Rezoning Transportation Analysis

Petition Number: 2023-041

Revision Log:	Date	Description
	7-26-23	First Review (PDM)
	03-20-24	Second Review (KC)

SHEET NUMBER
RZ-01

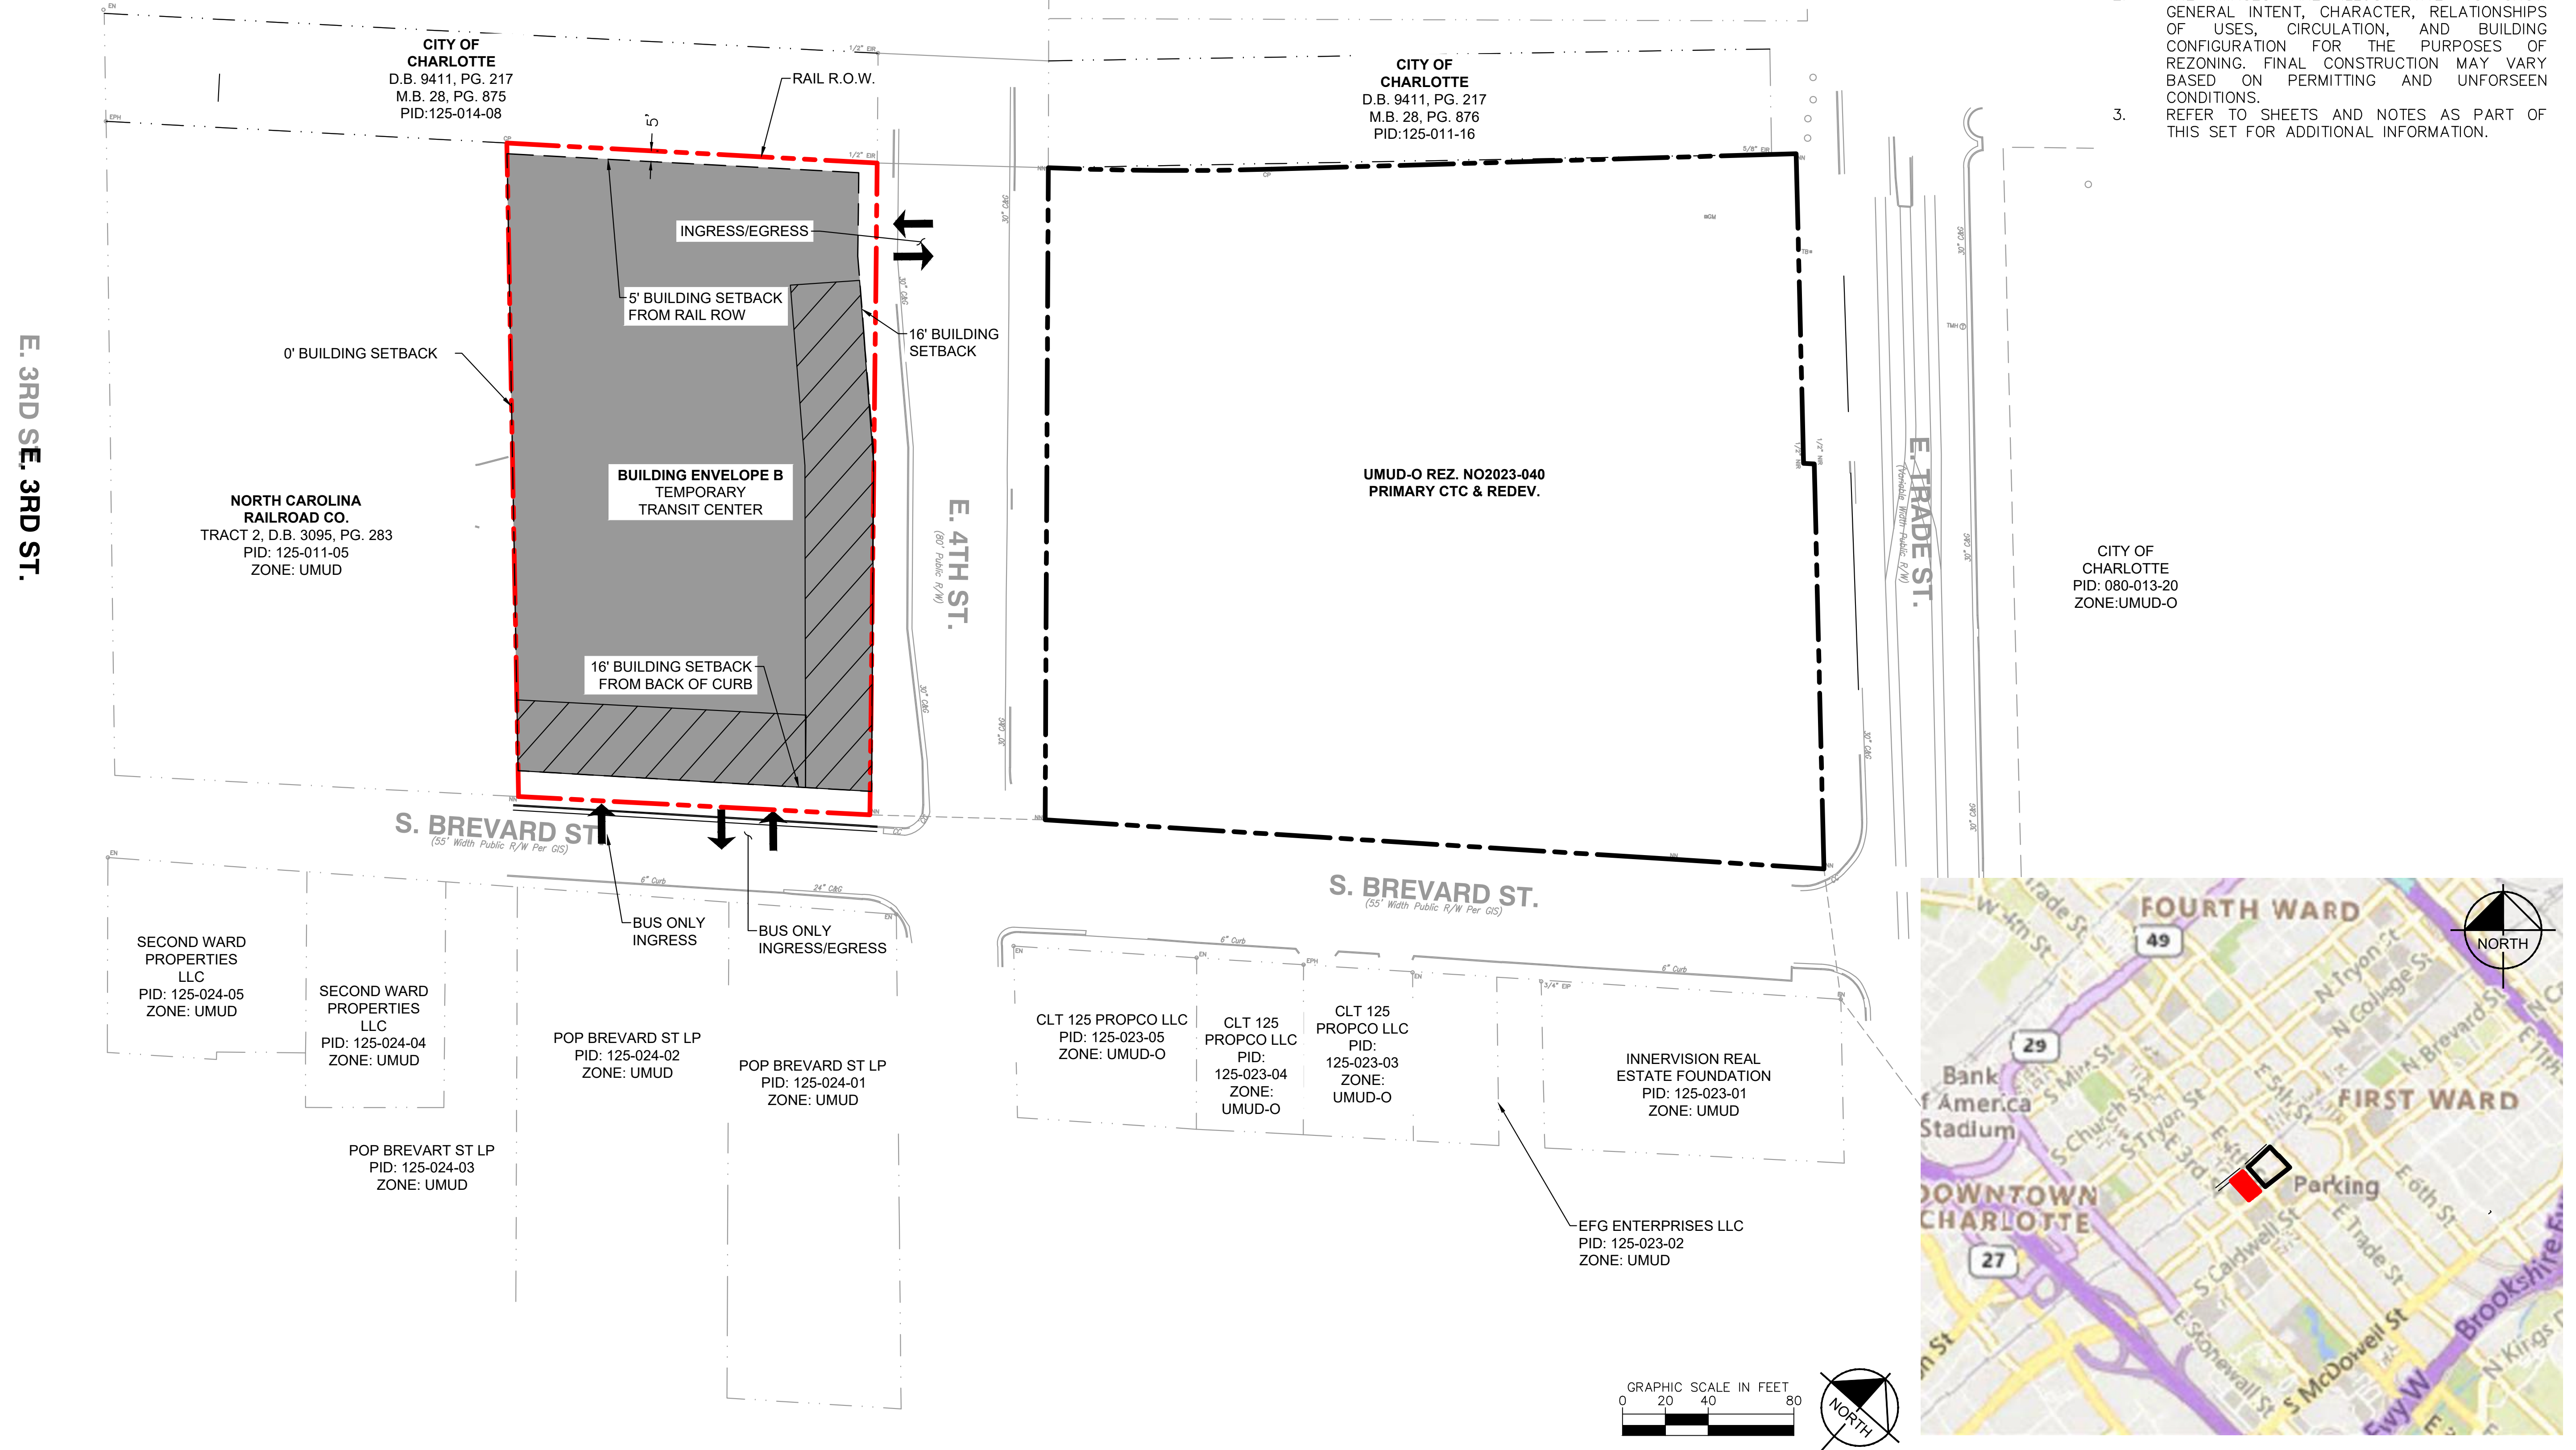
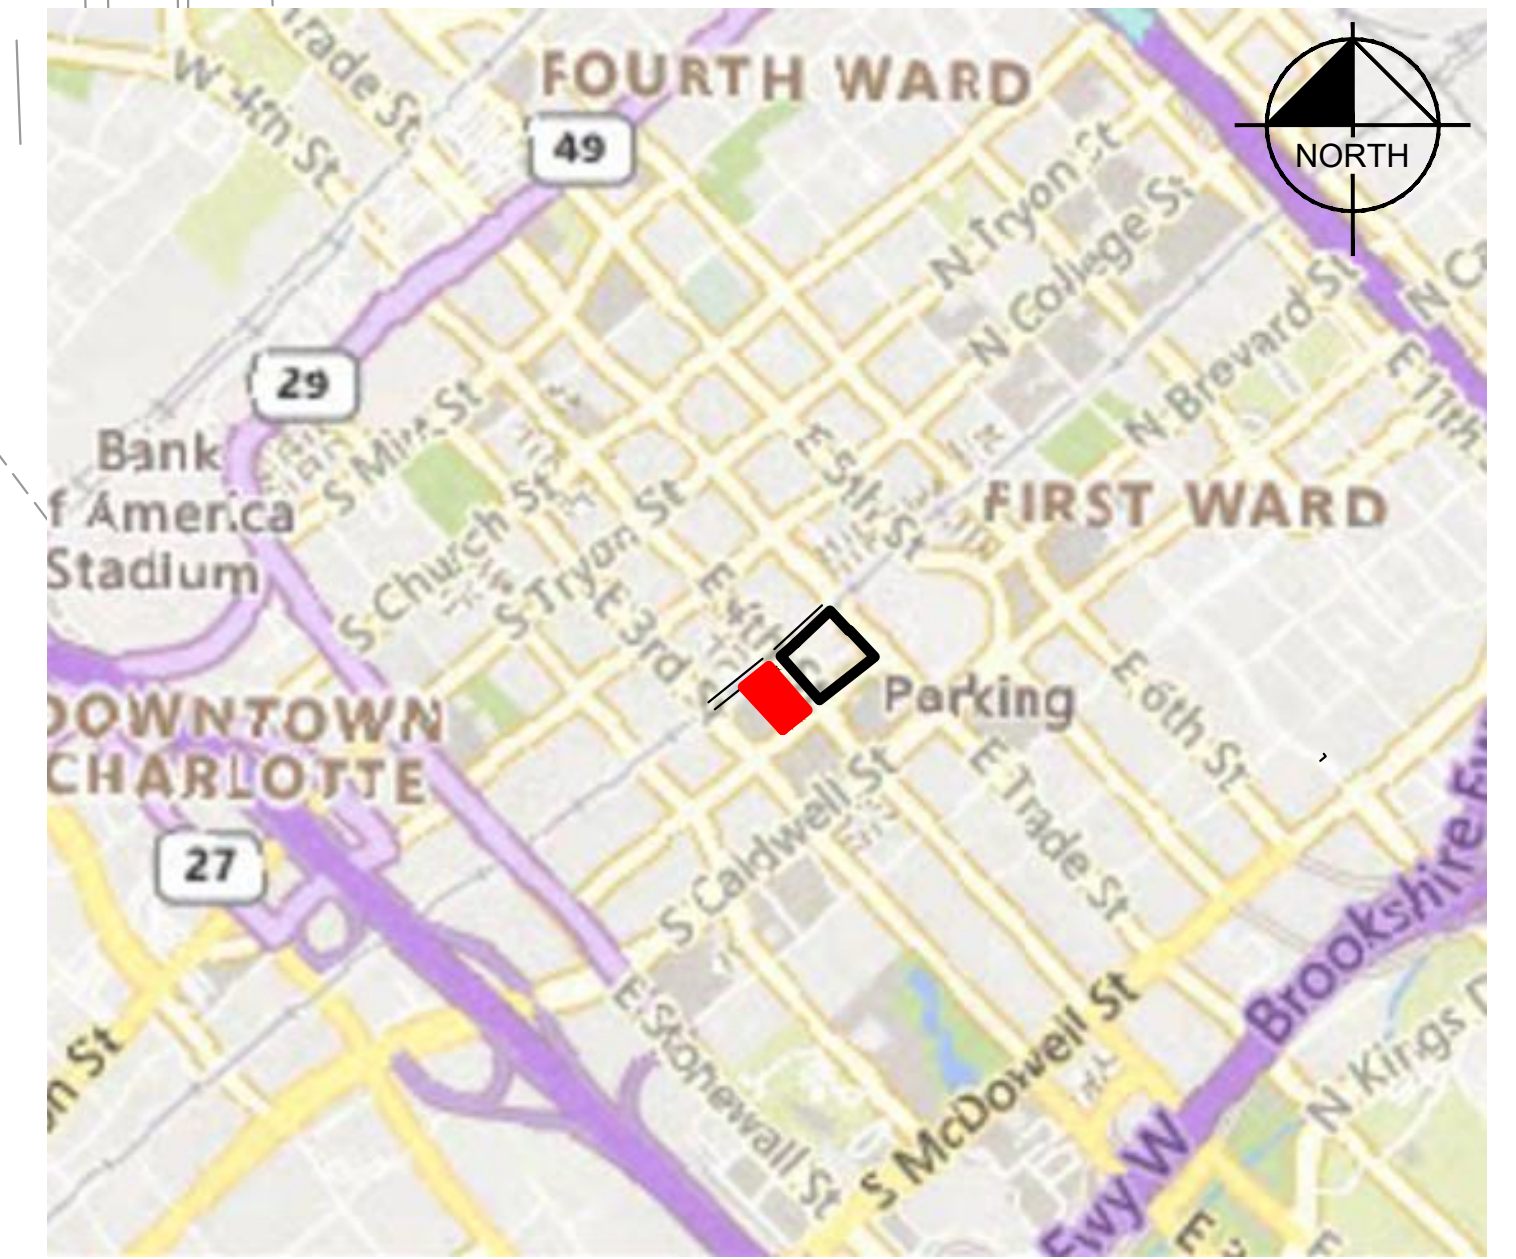
- 4. **Outstanding Comment 03-20-24:** Revise site plan and conditional note(s) to commit to dedicate a minimum of 40 feet of right-of-way from the road centerlines of Brevard Street and 4th Street if it does not exist today. The site plan shall label and dimension the right-of-way from the road centerline.

Clarifying Comment 03-20-24: Site plan needs to be updated to show a minimum of 40 feet of right-of-way from the road centerline to meet city ordinance.

- 5. **Outstanding Comment 03-20-24:** Revise site plan and conditional note(s) to commit to construct bicycle facilities by installing a multi-use path on Brevard Street and 4th Street to meet the Council-adopted Charlotte BIKES Policy. Multi-use paths maintained by the City shall meet ADA/PROWAG requirements.

6. **Outstanding Comment 03-20-24:** Revise site plan and conditional note(s) to commit to provide the streetscape for Uptown Signature Streets on Brevard Street and the streetscape for Uptown Primary Streets on 4th Street.

7. **Outstanding Comment 03-20-24:** Revise site plan and conditional notes to provide a 12ft rail trail along the Blue Line and provide a connection to the Rail Trail to the site. Design must accommodate bicycle operations.

Clarifying Comment: Update and revise site plan to accommodate for the rail trail as shown below.
